January 3<sup>rd</sup>, 2024

RE: Colorado Springs Planning Land Use Review – Colorado Aerospace Business Center

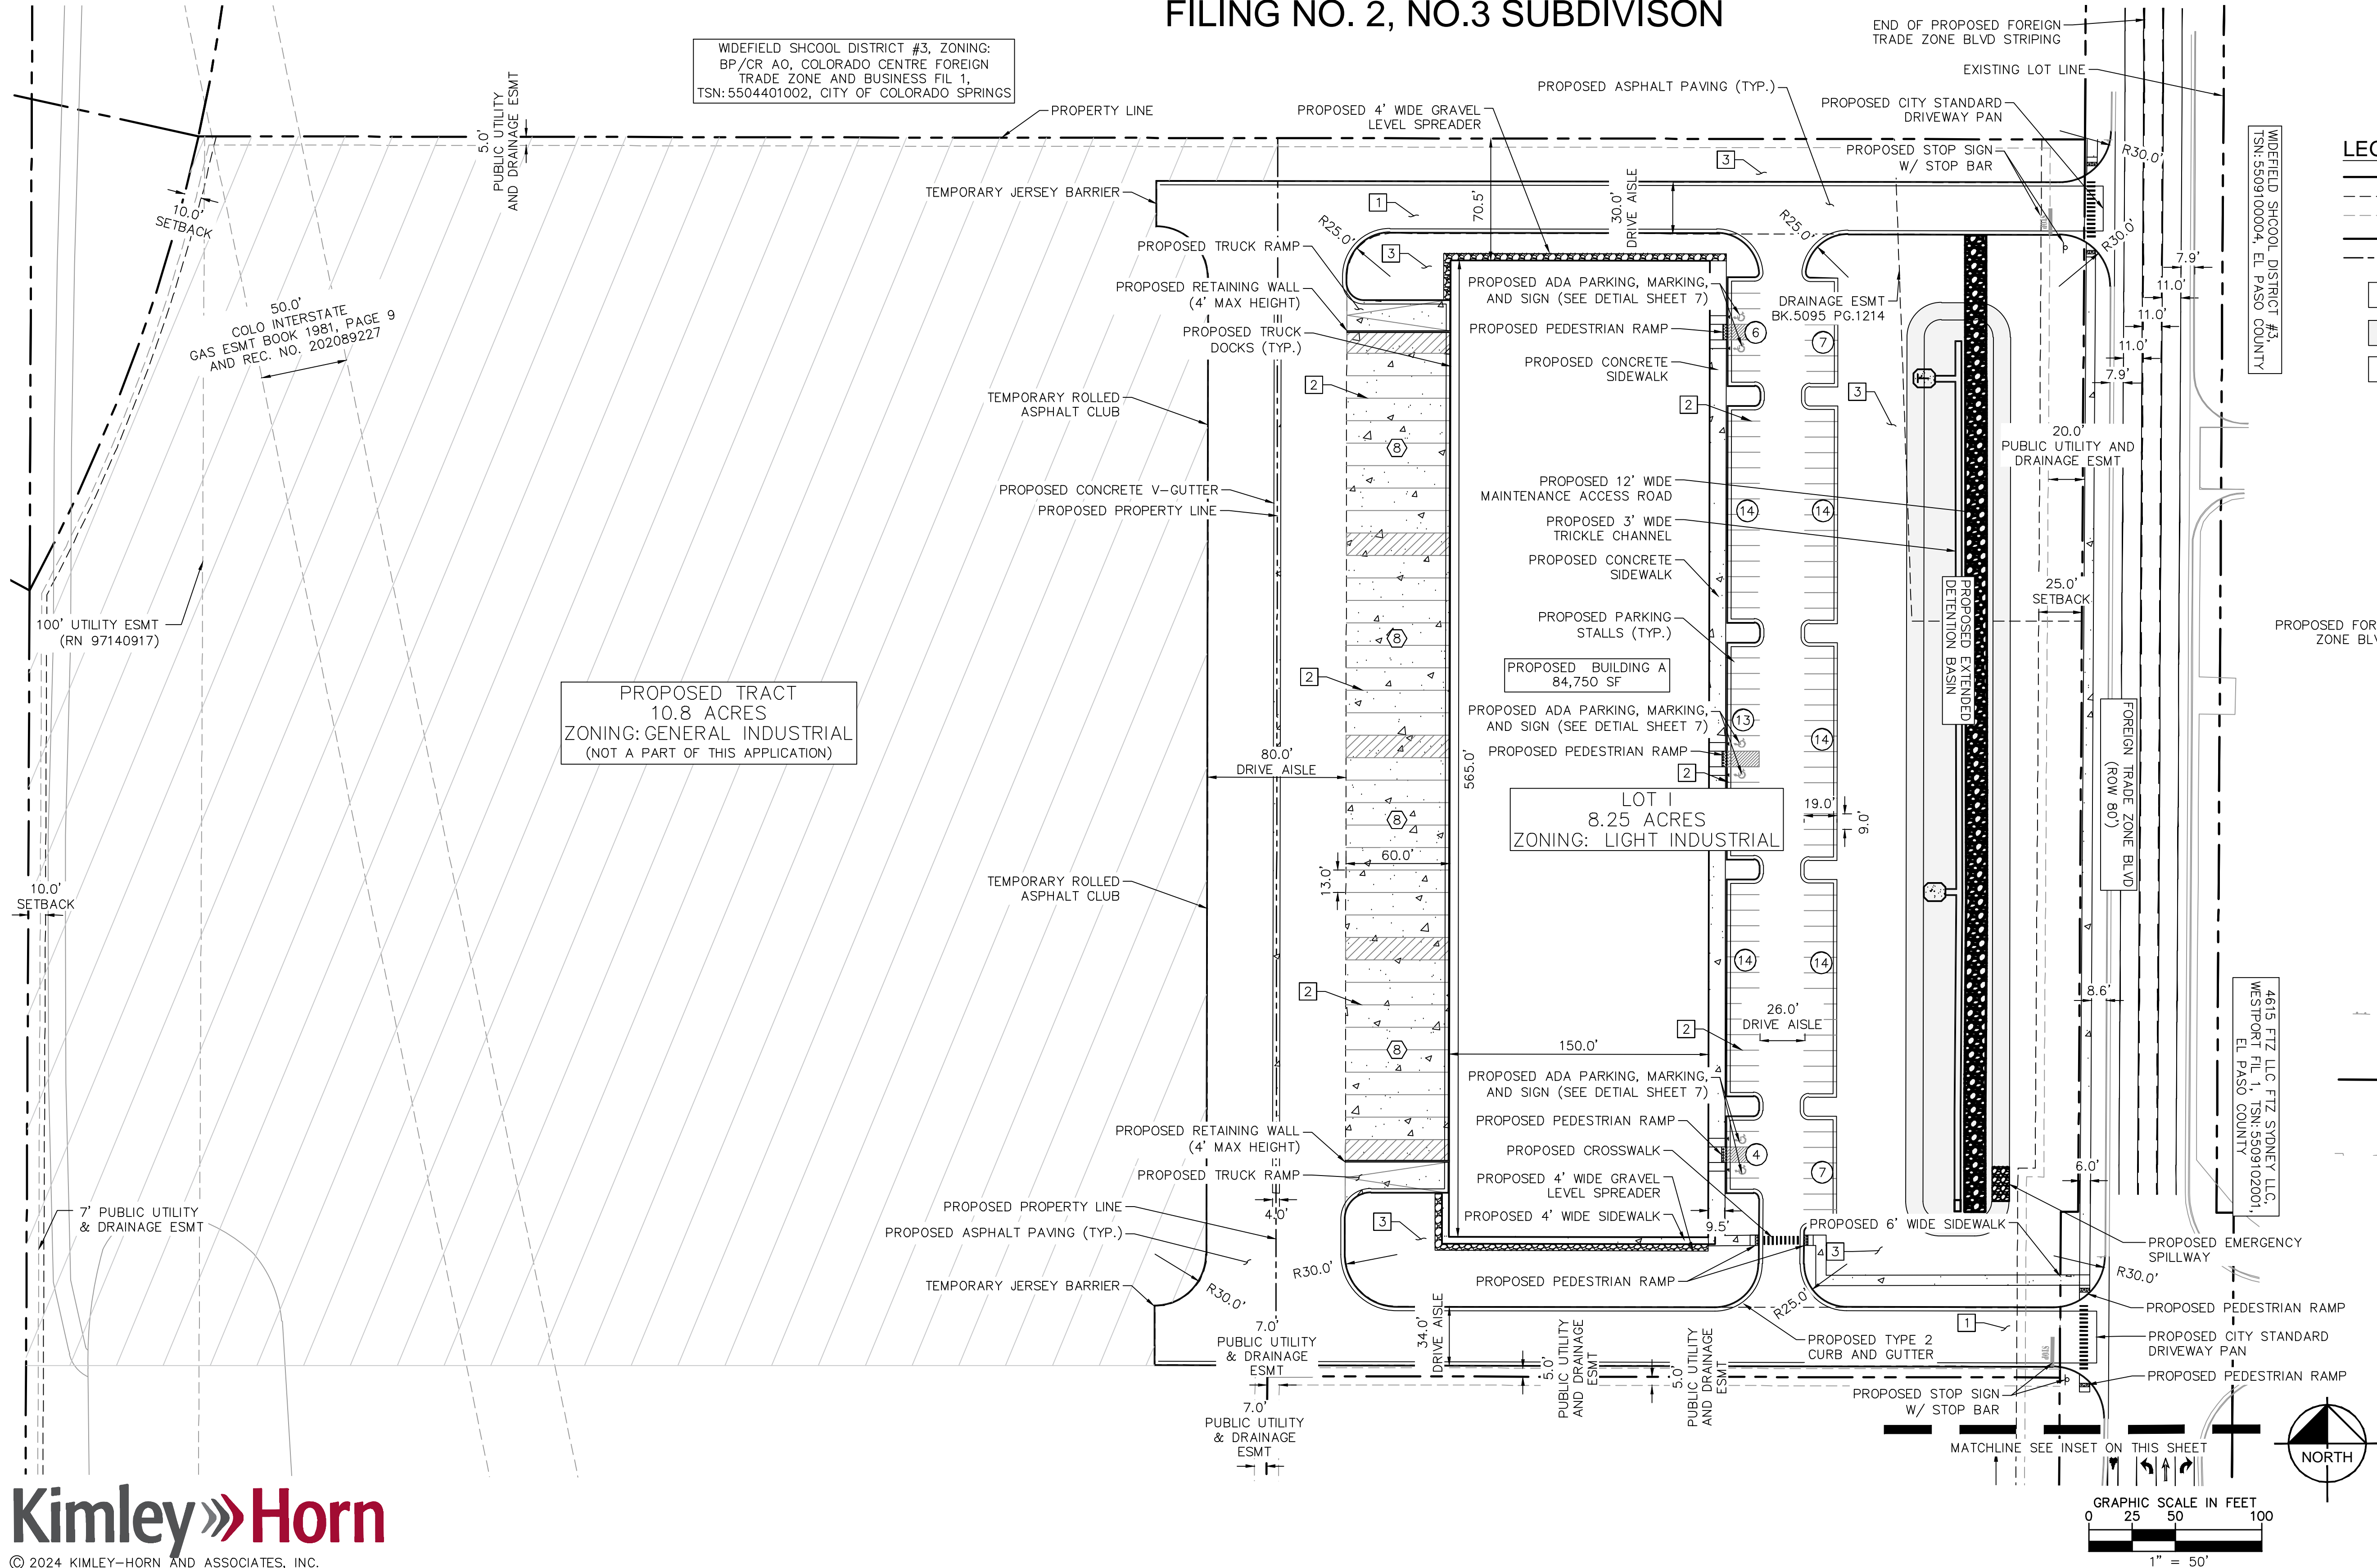
- 5' sidewalks along Foreign Trade and 6' along Bradley Road
- Construction drawings for all public improvements along foreign trade (assurances must be posted prior to approval)
- Need a minimum 20' from north property line to north access
- Foreign Trade Zone repaint will be required

- With 10' lanes and 7.5' buffers we can fit within the 45'+/- spacing, a cross section will need to be provided
- Need TIS
- RI/RO along Bradley is too close to access for development to the west
  - Approximately 40-50' east.
  - Relocated
- Only re-striping for now on Foreign Trade for Phase 1
- \$100k for future signal at Foreign Trade and Bradley
- Cross pans at entrances have to be concrete, then can go to asphalt

- Max height proposed by us is 47'
  - We are under this
- 26' minimum driveway width required for the building height
  - We were showing 24' on the north side of Building A
  - We have changed this to 26'

LANDSCAPE PLAN
SHEET 10 OF 21

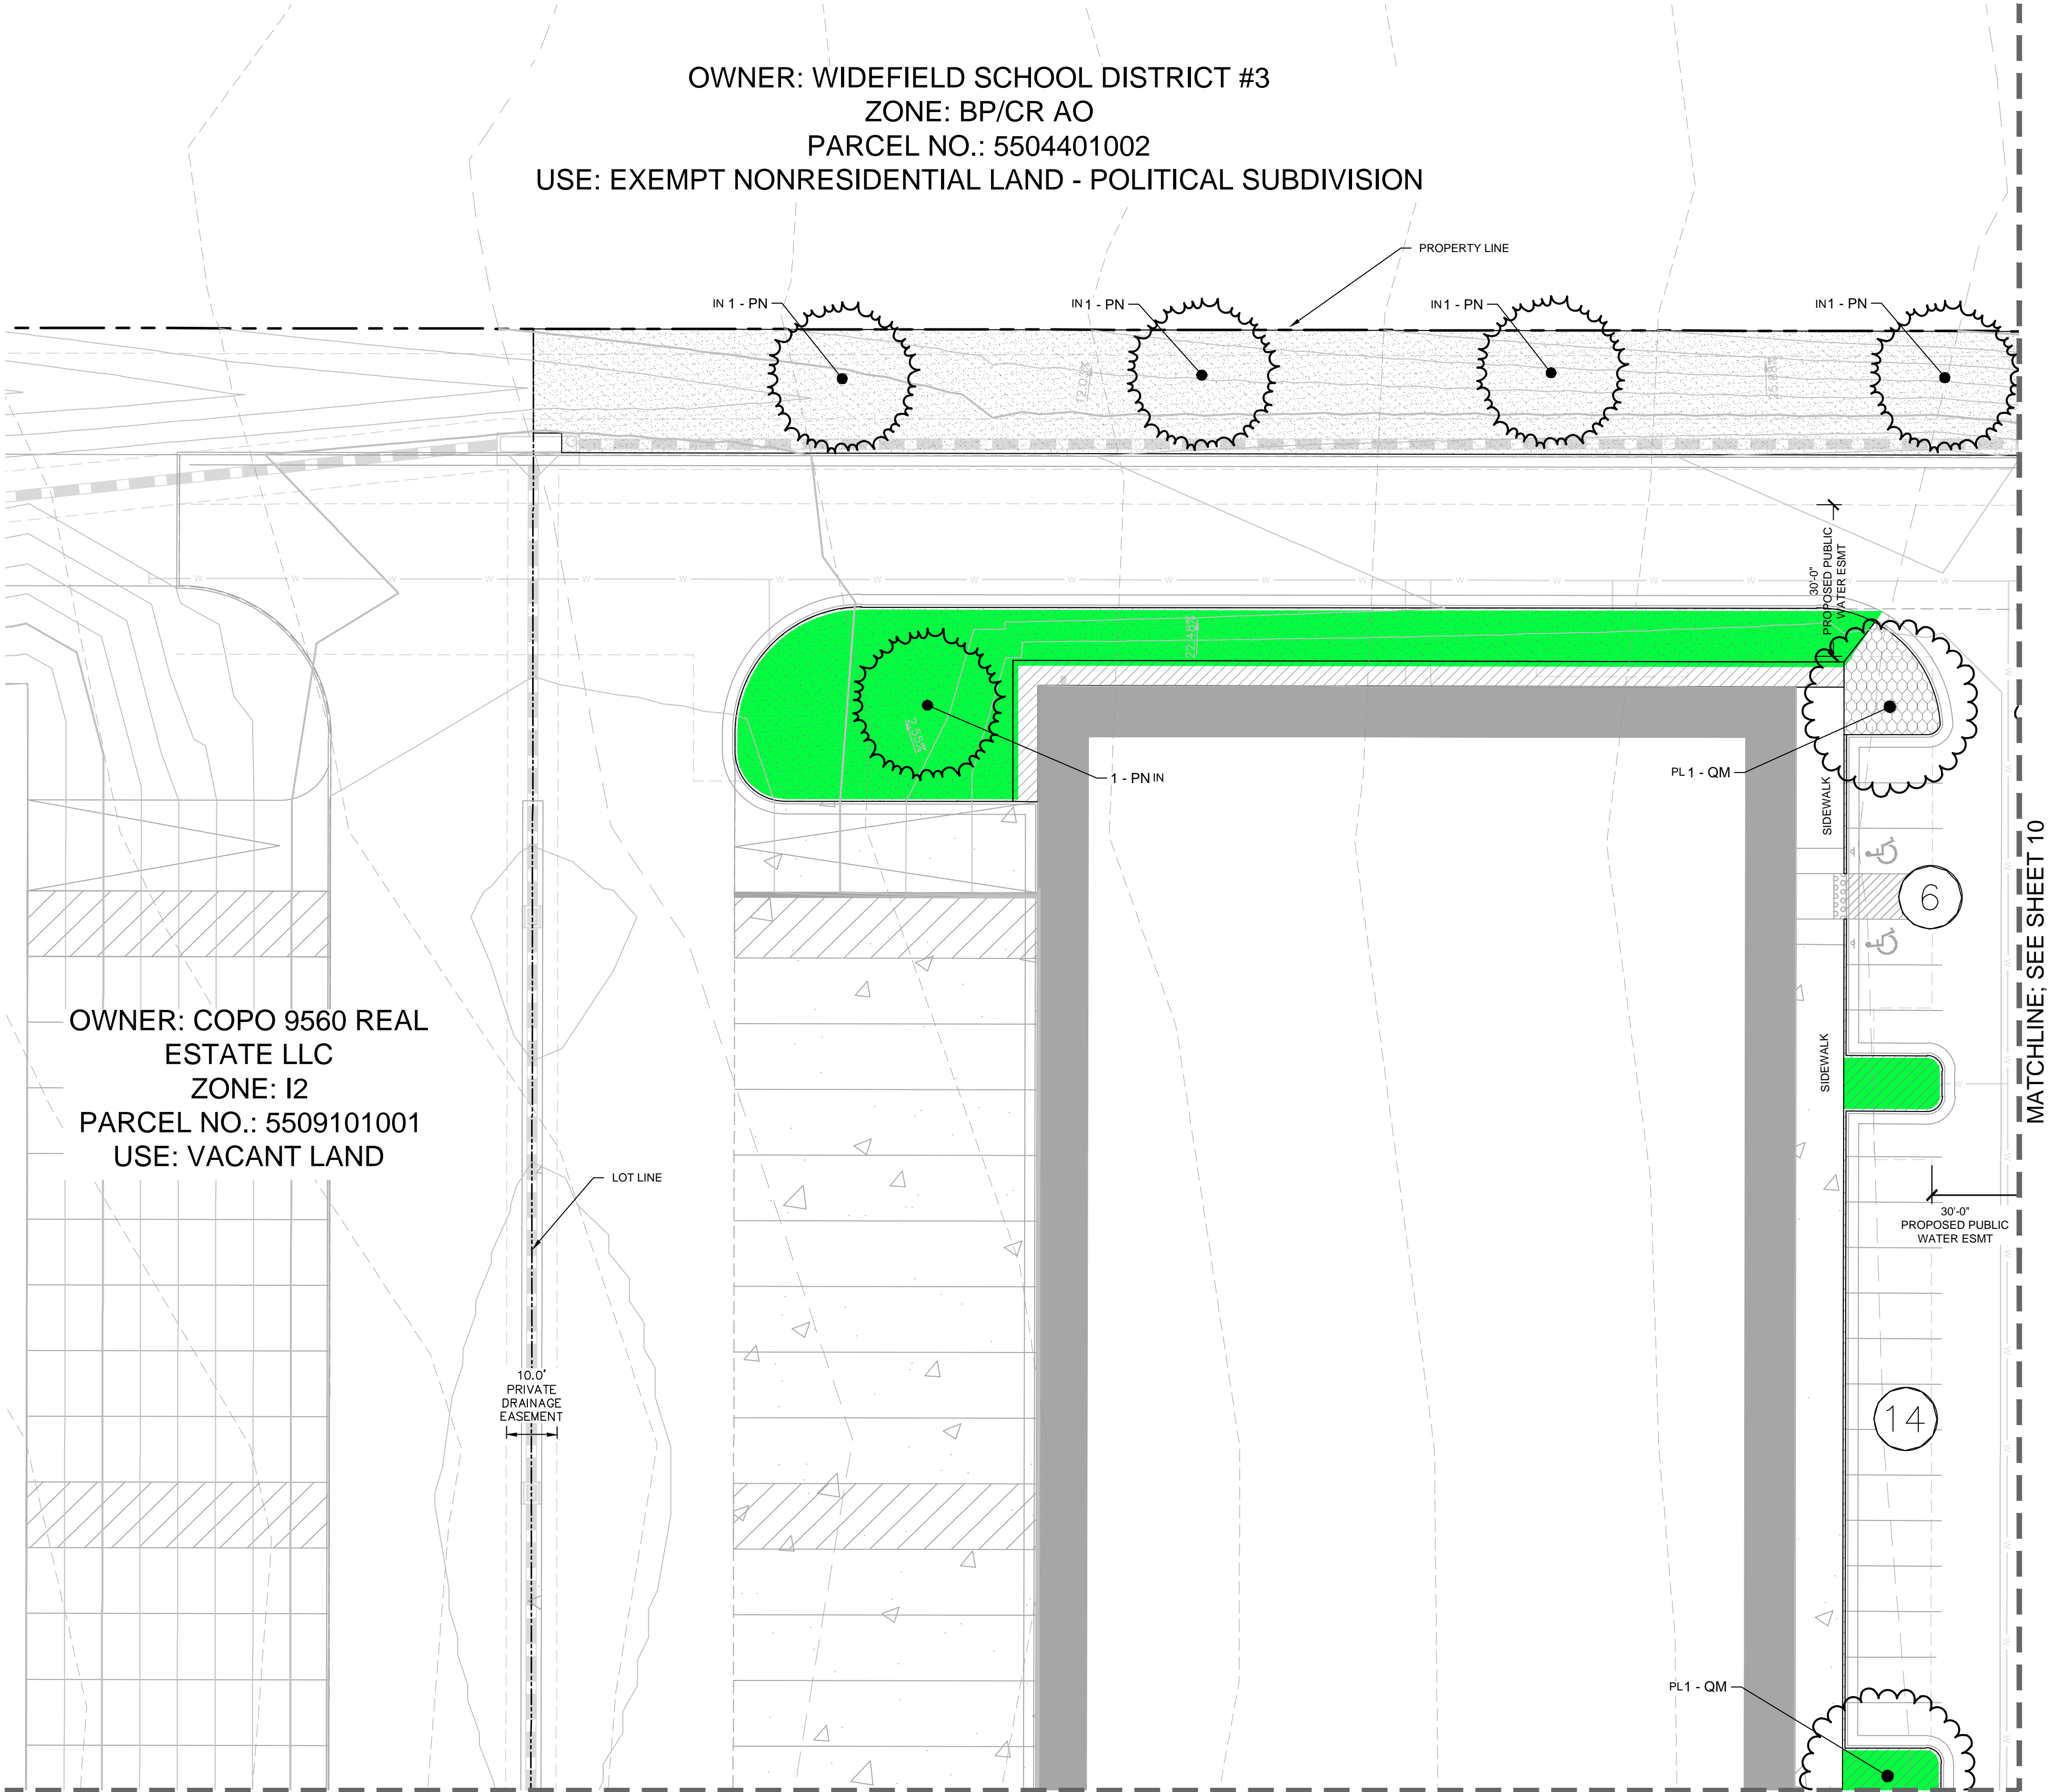
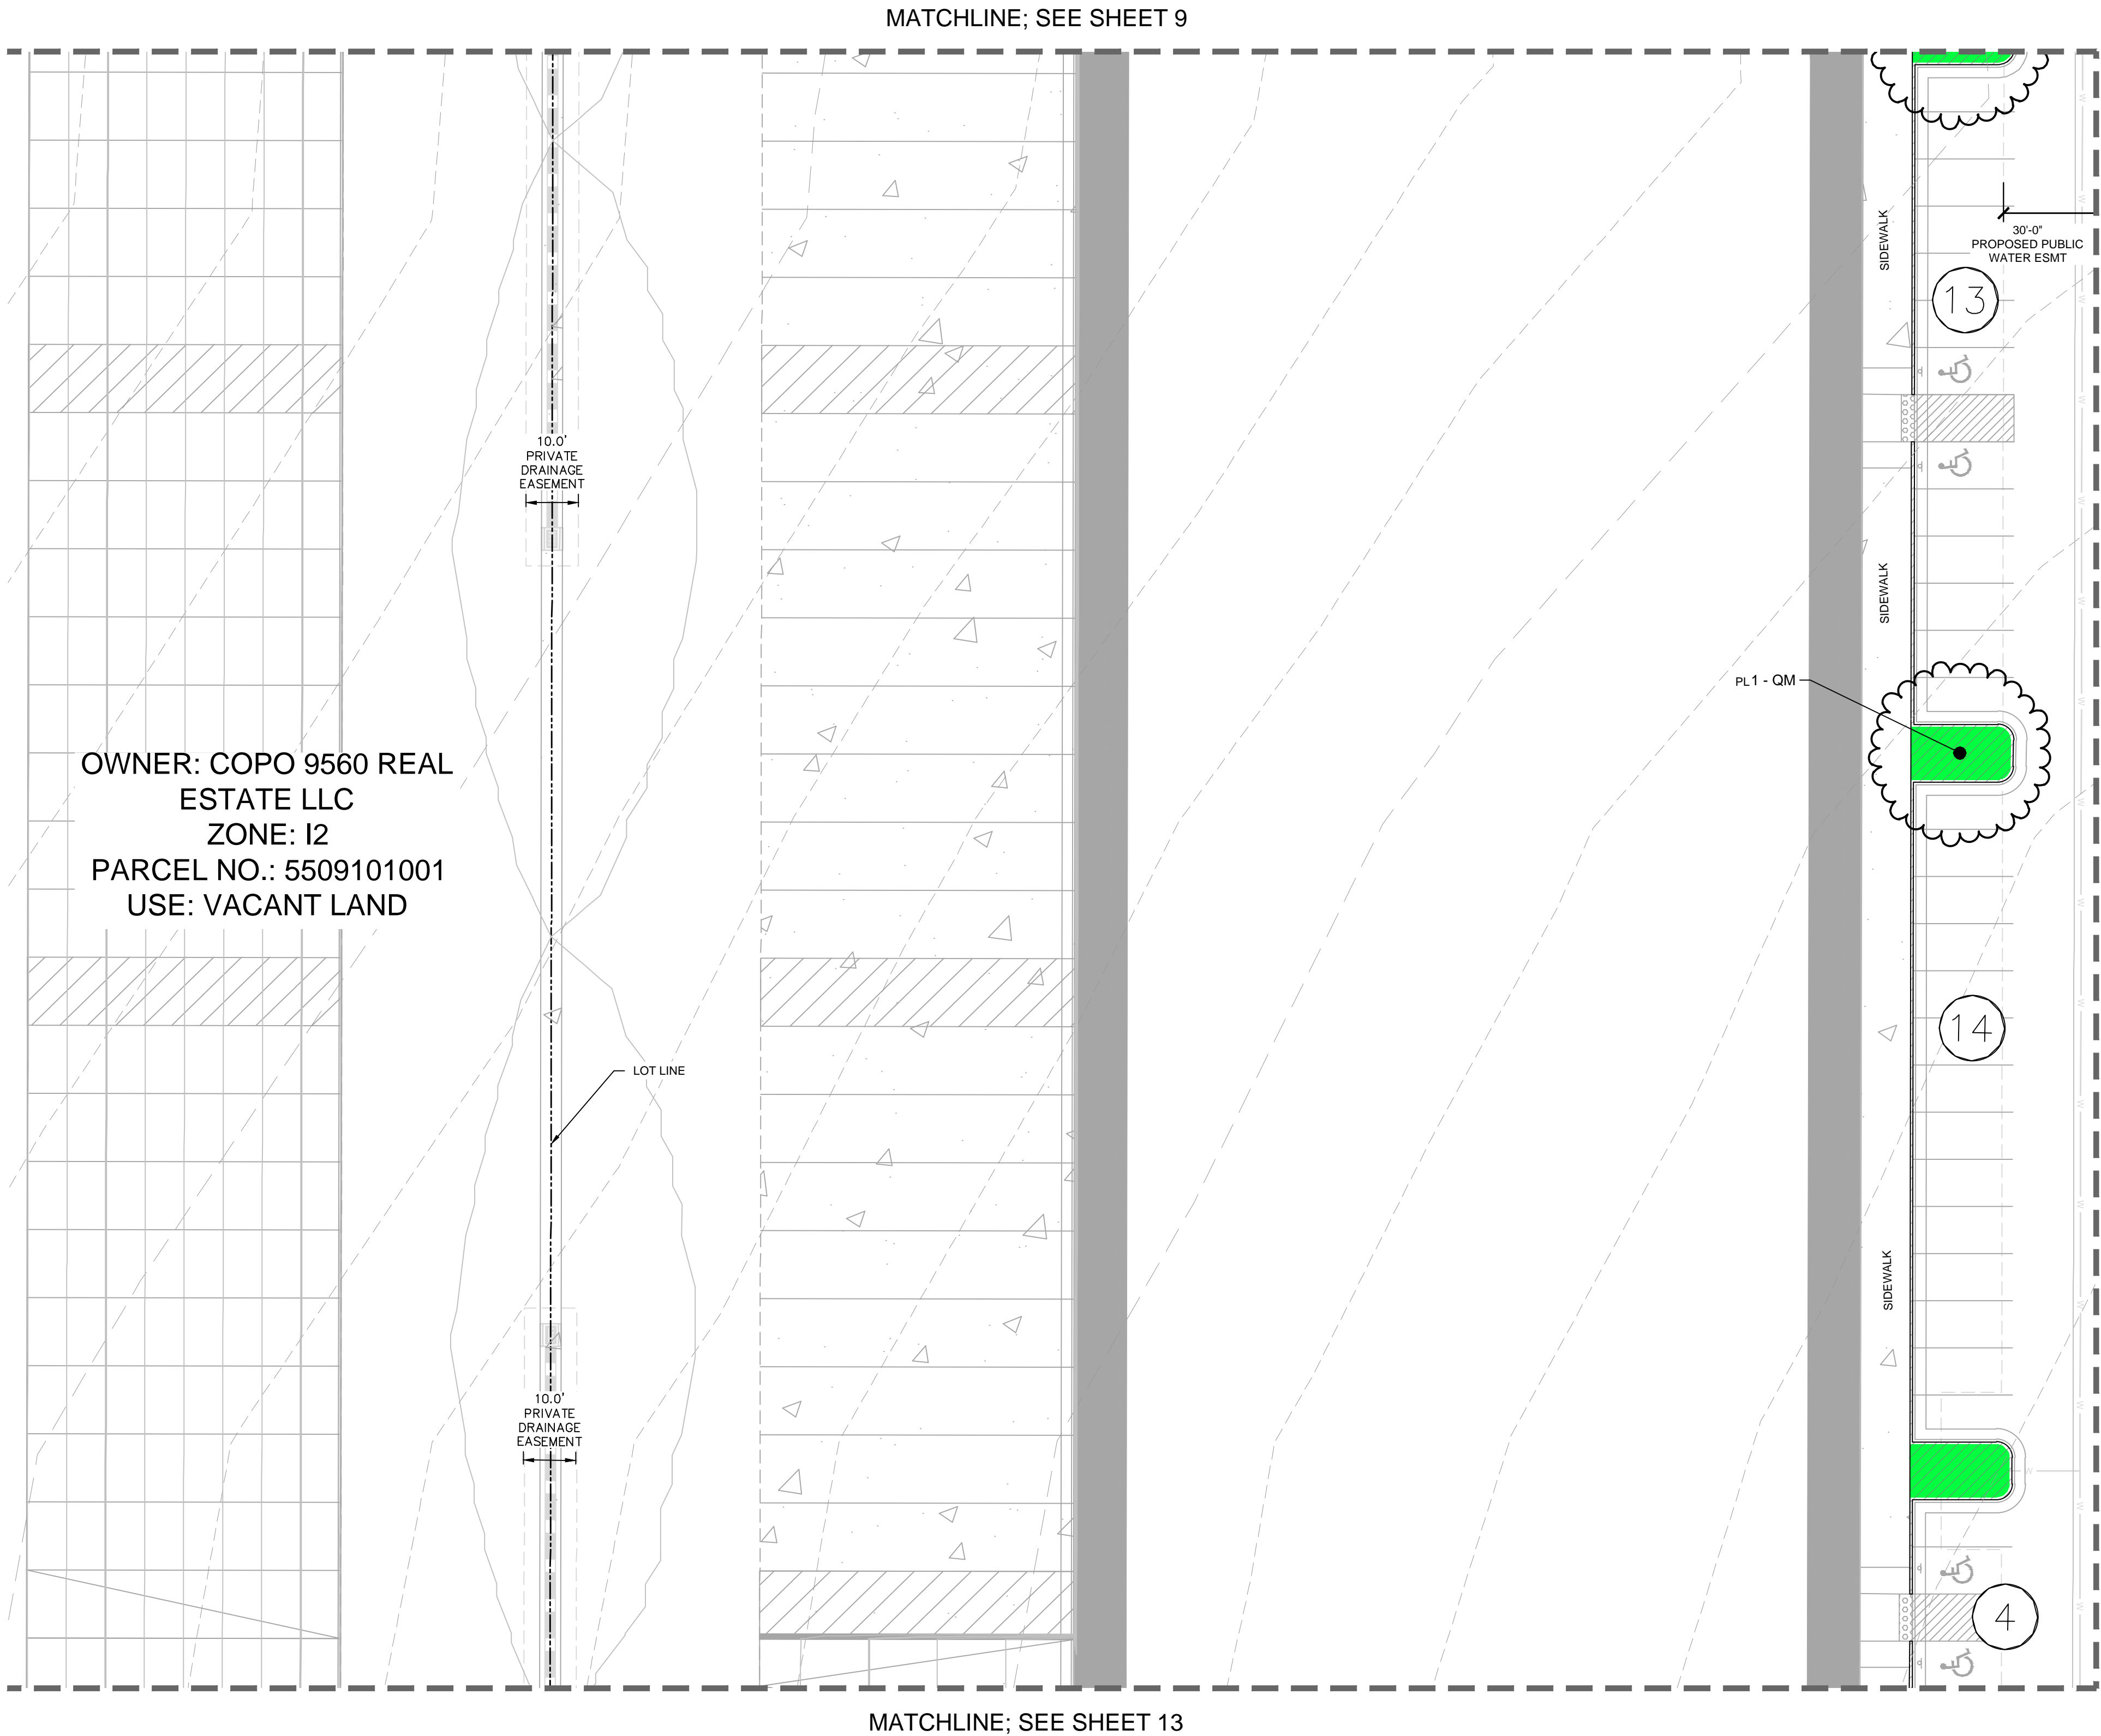
- 25' LS setback along Foreign Trade and 1 tree per 25' of frontage
- Need screening along Foreign Trade
- Overall development needs "robust" screening from adjacent developments to buildings
  - 15' buffer from west property line
